**KIRKLEES METROPOLITAN COUNCIL
INVESTMENT & REGENERATION SERVICE**

**DELEGATED DECISION TO DETERMINE APPLICATIONS FOR
CONSENT, AGREEMENT OR APPROVAL REQUIRED BY CONDITION**

Reference No:	2024/44/92701/E
Site Address:	South Pennine Boat Club, Wood Lane, Mirfield, WF14 0ED
Description:	Discharge of details reserved by condition 4 (Phase I Report) on previous permission 2024/90013 for erection of extension and alterations to enclose dry dock
Recommending Officer:	Nicole Helliwell

Figure 6: Schematic of proposed workshop and surroundings

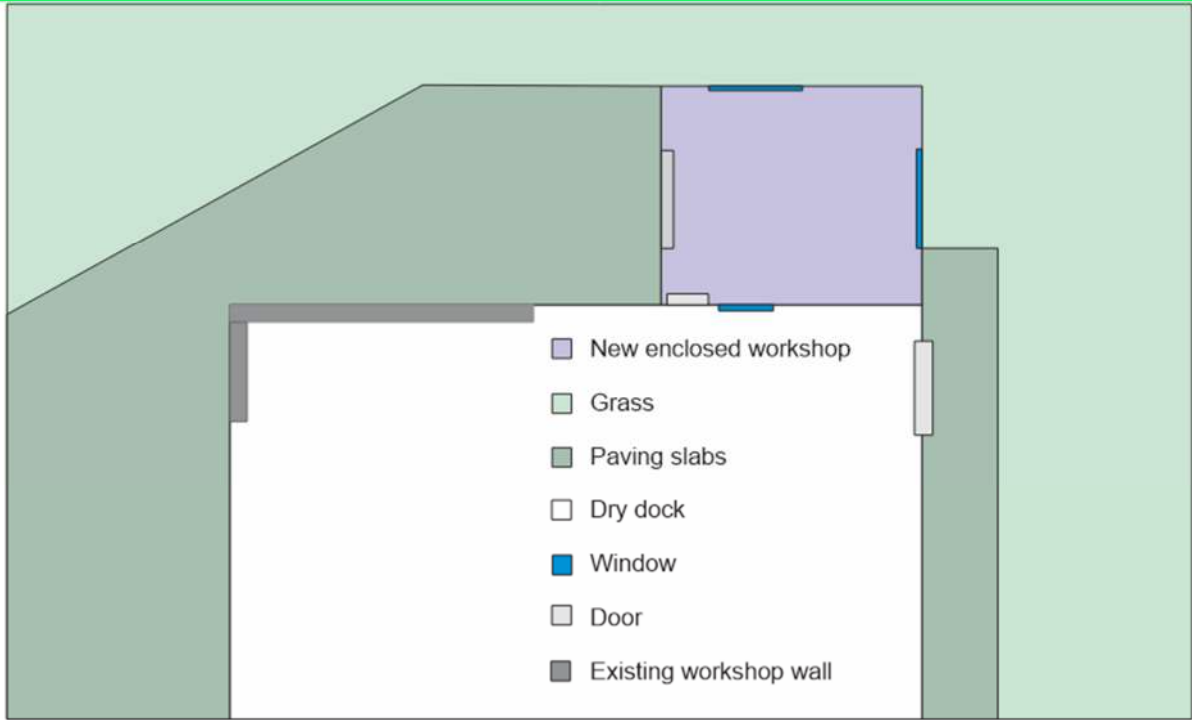
Despite the very low, low to negligible risk, the report goes on to suggest site remediation, including testing of soils and a vapour barrier in addition to a reinforced concrete slab. Therefore, KC Environmental Health would require clarification of this position with an application for the discharge of condition 5. Therefore, in order to move the application forward, Officers accept the phase 1 report.
